**KIRKLEES METROPOLITAN COUNCIL
INVESTMENT & REGENERATION SERVICE**

DELEGATED DECISION TO DETERMINE PLANNING APPLICATIONS

Reference No:	2024/62/92062/W
Site Address:	Former Staff Car Park, Land of Willow Lane, Birkby, Huddersfield, HD1 5EB
Description:	Change of use of land for siting of a secure self-storage facility (maximum of 93 movable storage containers) (within a Conservation Area)
Recommending Officer:	Katie Chew

DECISION – CONDITIONAL FULL PERMISSION

PROPOSED SITE PLAN

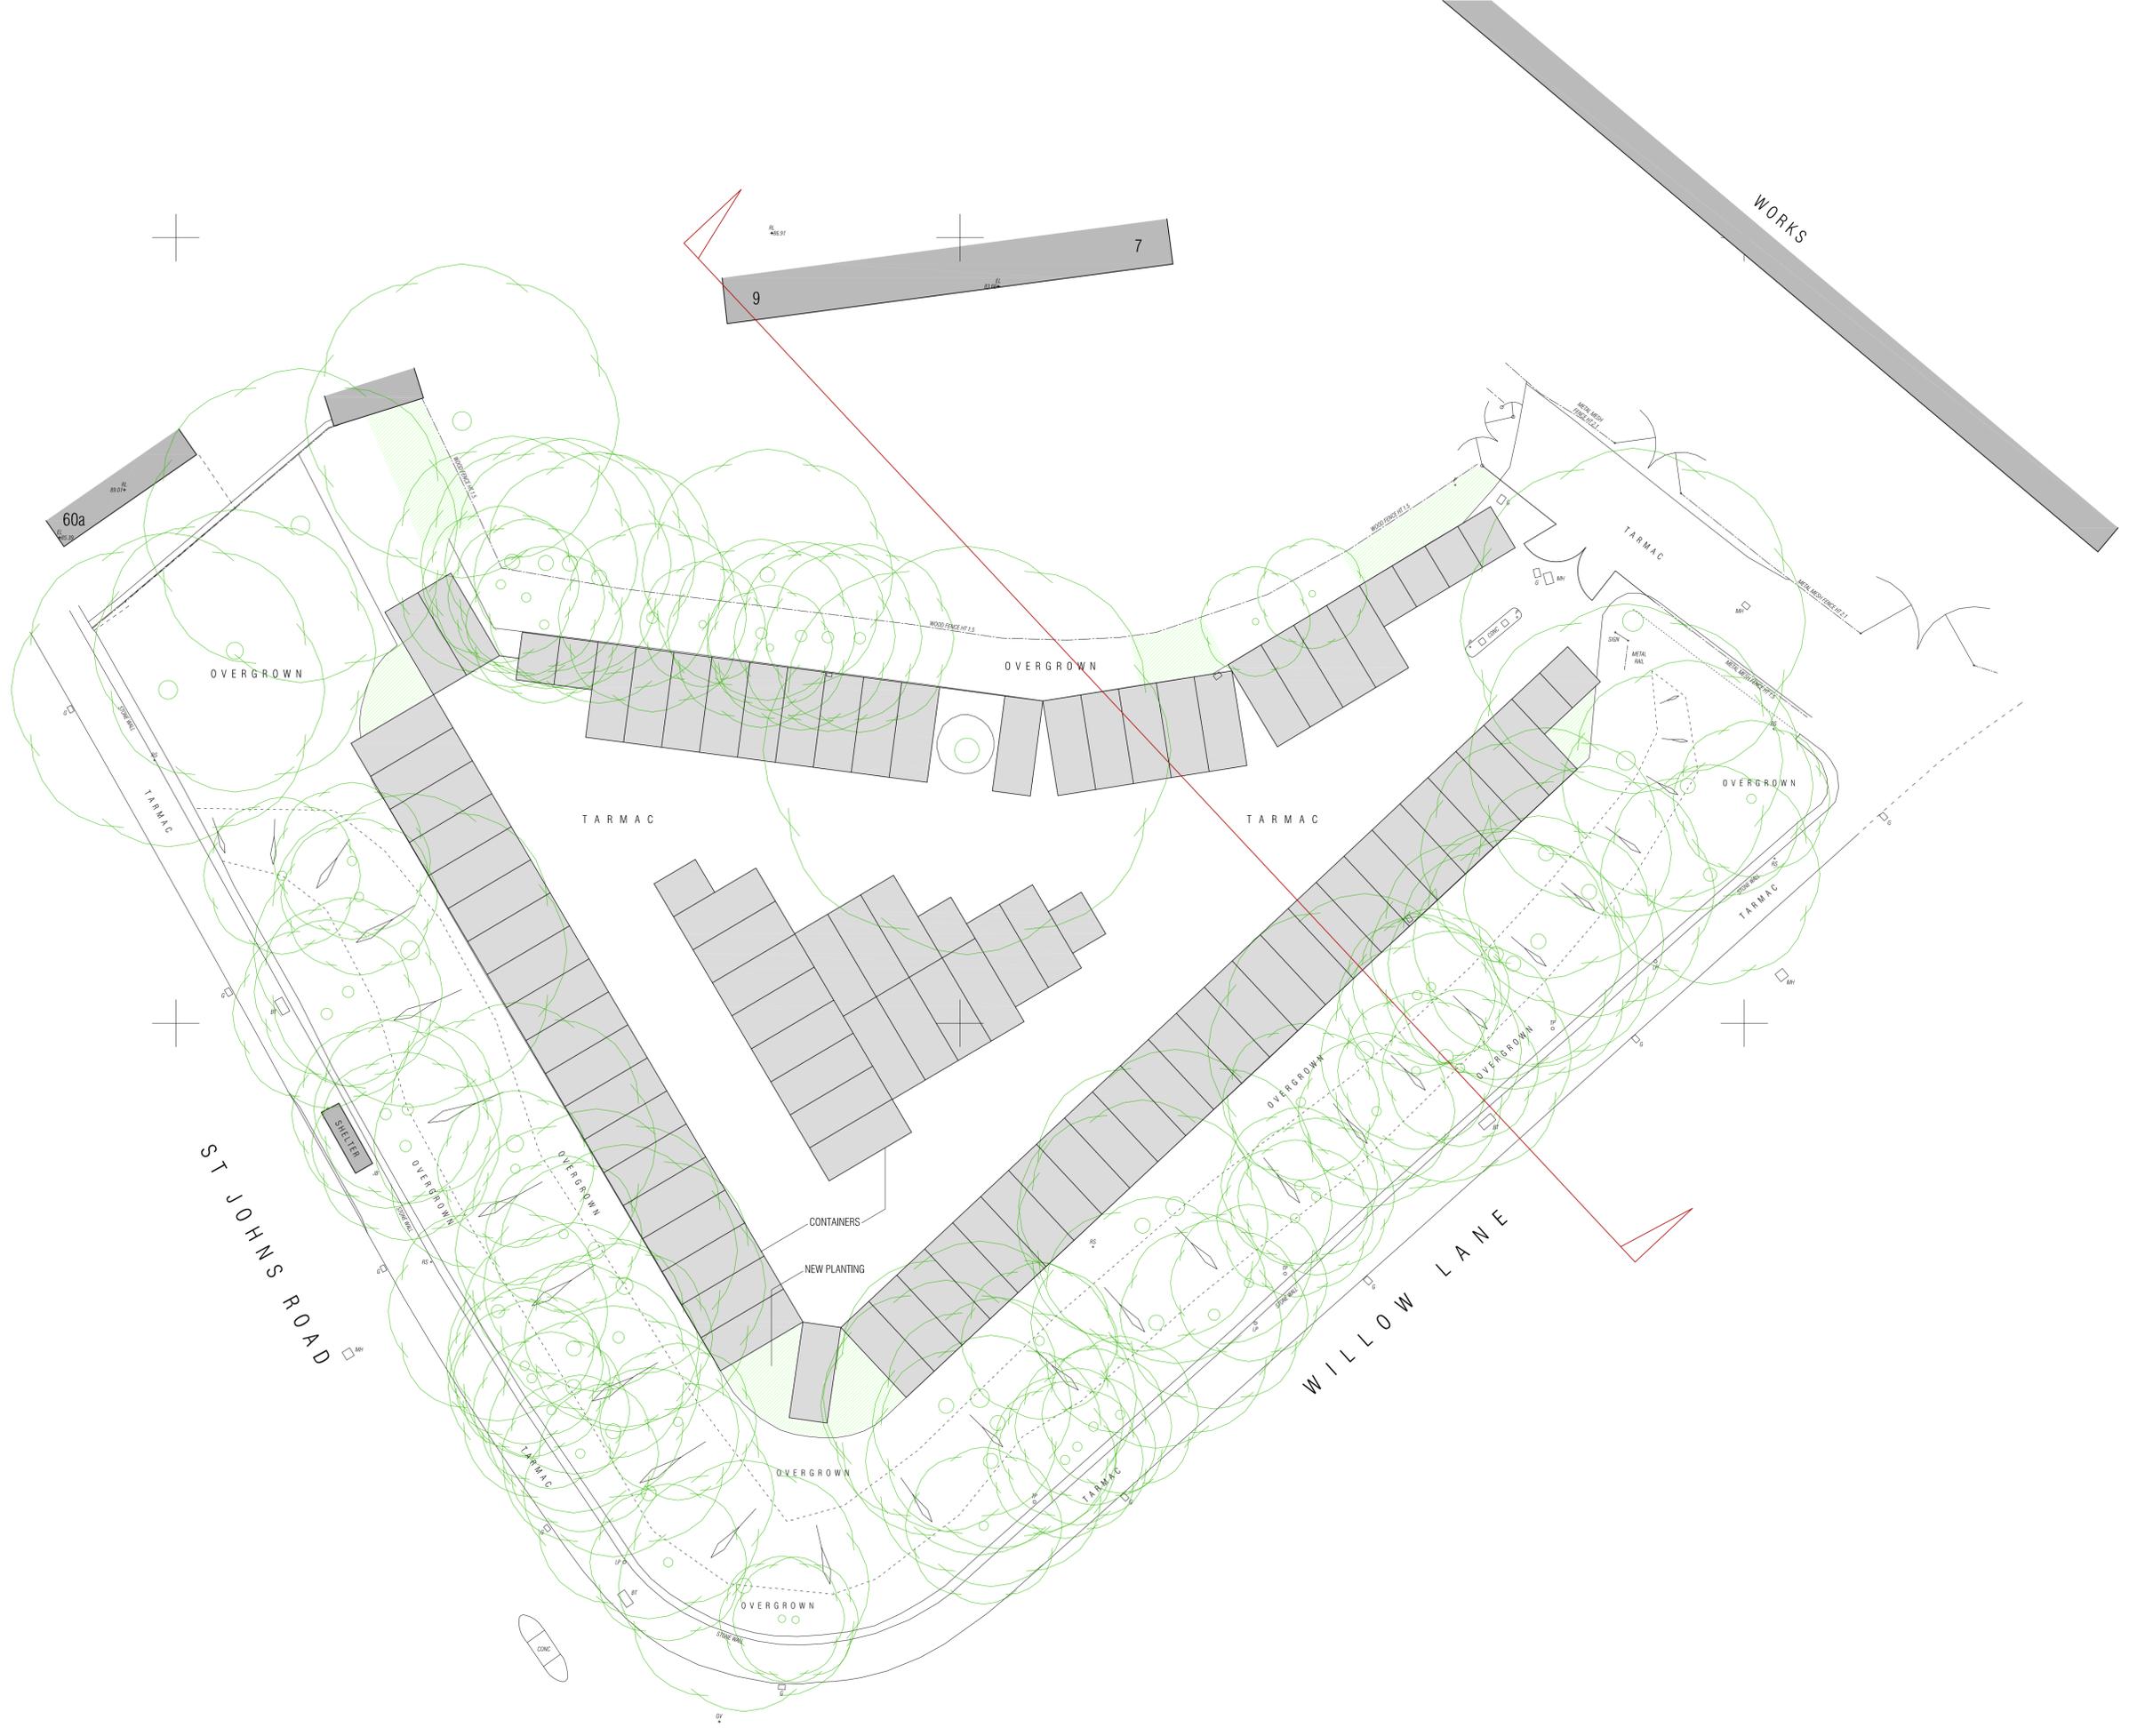
Highway Development Management (informal) – Comments received 17th October 2024. Highway Officers queried how the site would operate and be managed and therefore requested the submission of a site management plan,

they also queried whether there would be a need for waste storage on site, and if so waste storage and collection points must be shown on plan. Officers also requested the submission of a swept path analysis to show that a Kirklees fire service vehicle can both access and turn within the site in case of an emergency and provision of 12 parking spaces for customers and staff within the site.

Officer note: Following receipt of the above comments, the applicant's agent has provided a swept path analysis, amended site plan which shows access arrangements, and an email which outlines how the site is to operate, details of any employees and waste storage.

Officer note: The Council's Highways Officers have appraised the further information and confirm that these details are acceptable and have no further objection to the proposals.

NEW PLANTING AREAS
 1.5m HIGH TIMBER FENCE TO SCREEN SITE

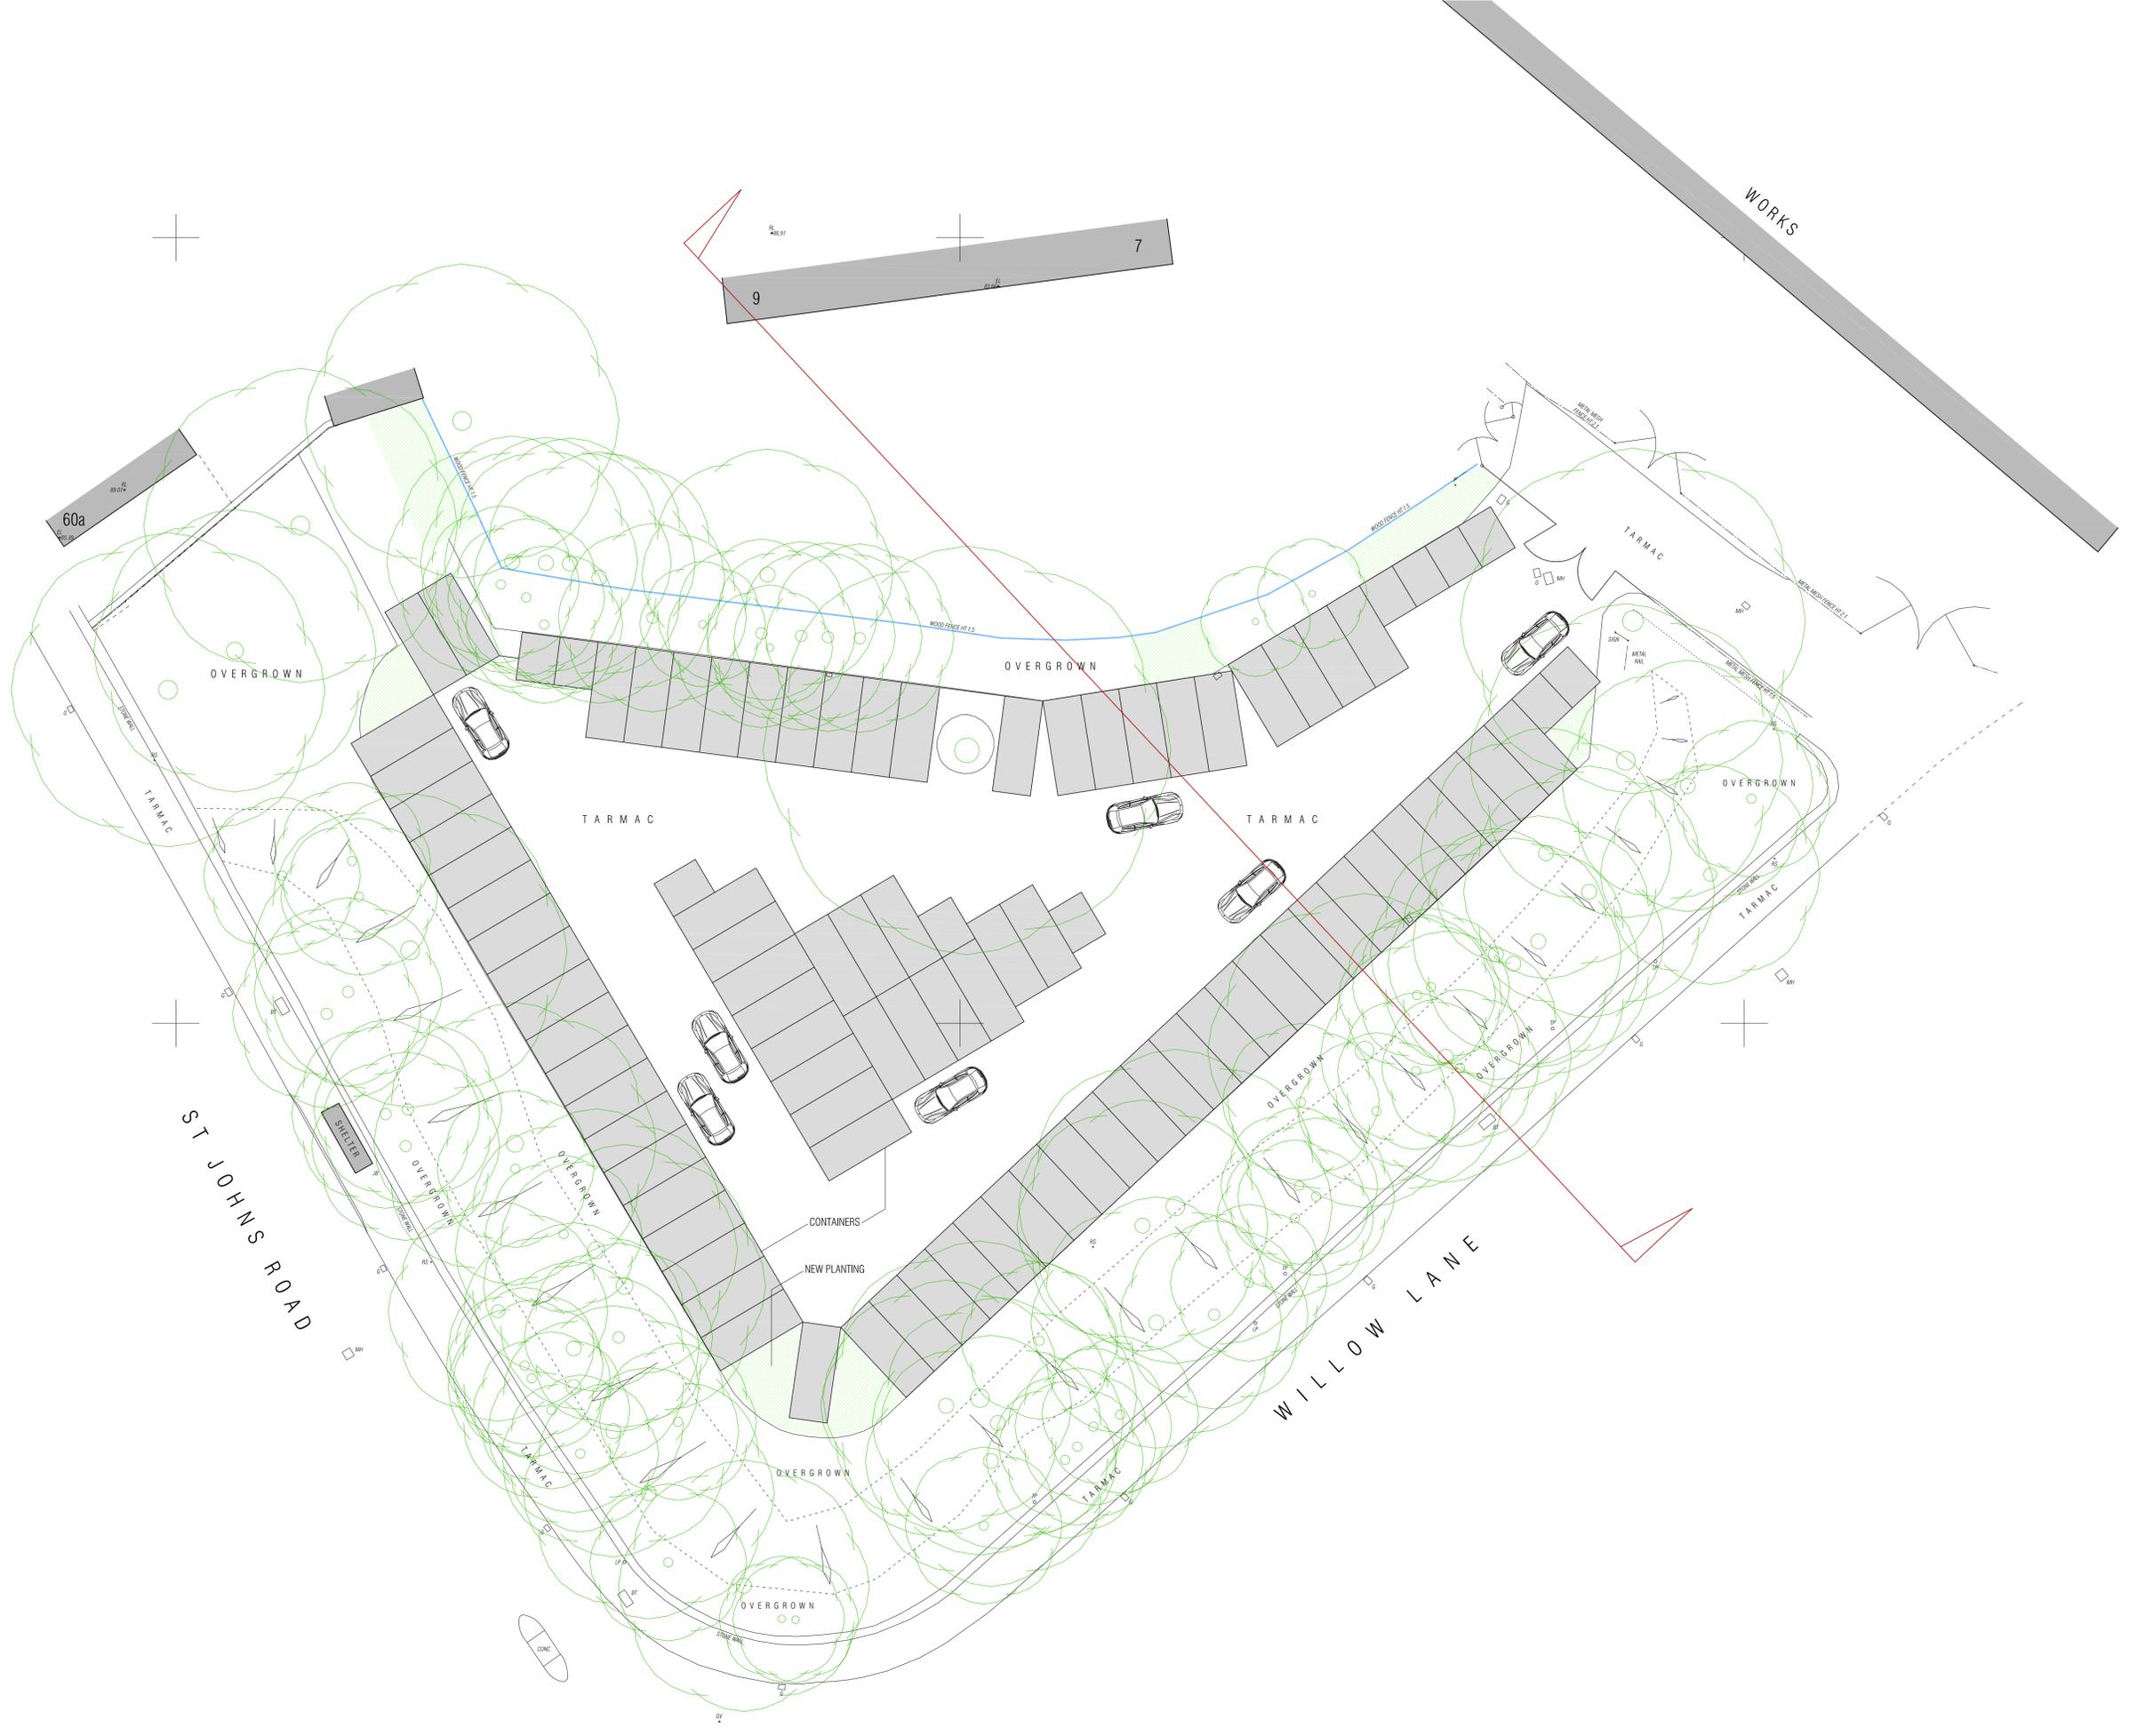
Additional information / clarification was requested in respect of the proposals and their impact on trees following on from comments received from the Council's Trees Officer. In addition, an amended plan was submitted which outlined the installation of a 1.5m high timber fence along the northern boundary of the site in line with comments received from the Council's Conservation & Design Officer. It was also agreed that the storage containers would be dark green/black in colour. Highways Officers also requested the submission of further information in respect of access, parking and storage of waste.

KC Conservation & Design (C&D) (informal) – Comments received 26th September 2024. No objections overall but do have some concerns in respect of the relationship between the proposed storage containers to the north of the site and the listed buildings nos. 7 & 9 Bay Hall. It was suggested that a hatched area be provided on plan of which the applicant would be unable to store containers, this is in the interests of preserving and enhancing the setting of these Listed Buildings. In addition to this, it was requested that the storage containers be of a dark colour such as black or dark green, to ensure that the containers blend in with the site and are not overly prominent.

Officer note: Following discussions with the applicant's agent it was agreed that providing a hatched area to the entrance of the site, adjacent to the above listed buildings would not be in the best interests of the operation of the site and may lead to the overall development not being viable for the applicant. The previous use of the site was for HGV storage and the containers are considered to have less impact than HGV's. A compromise was therefore considered to be achievable by provision of a 1.5m high timber fence along the northern boundary of the site to help provide additional screening of the proposed development. This is deemed to be acceptable.
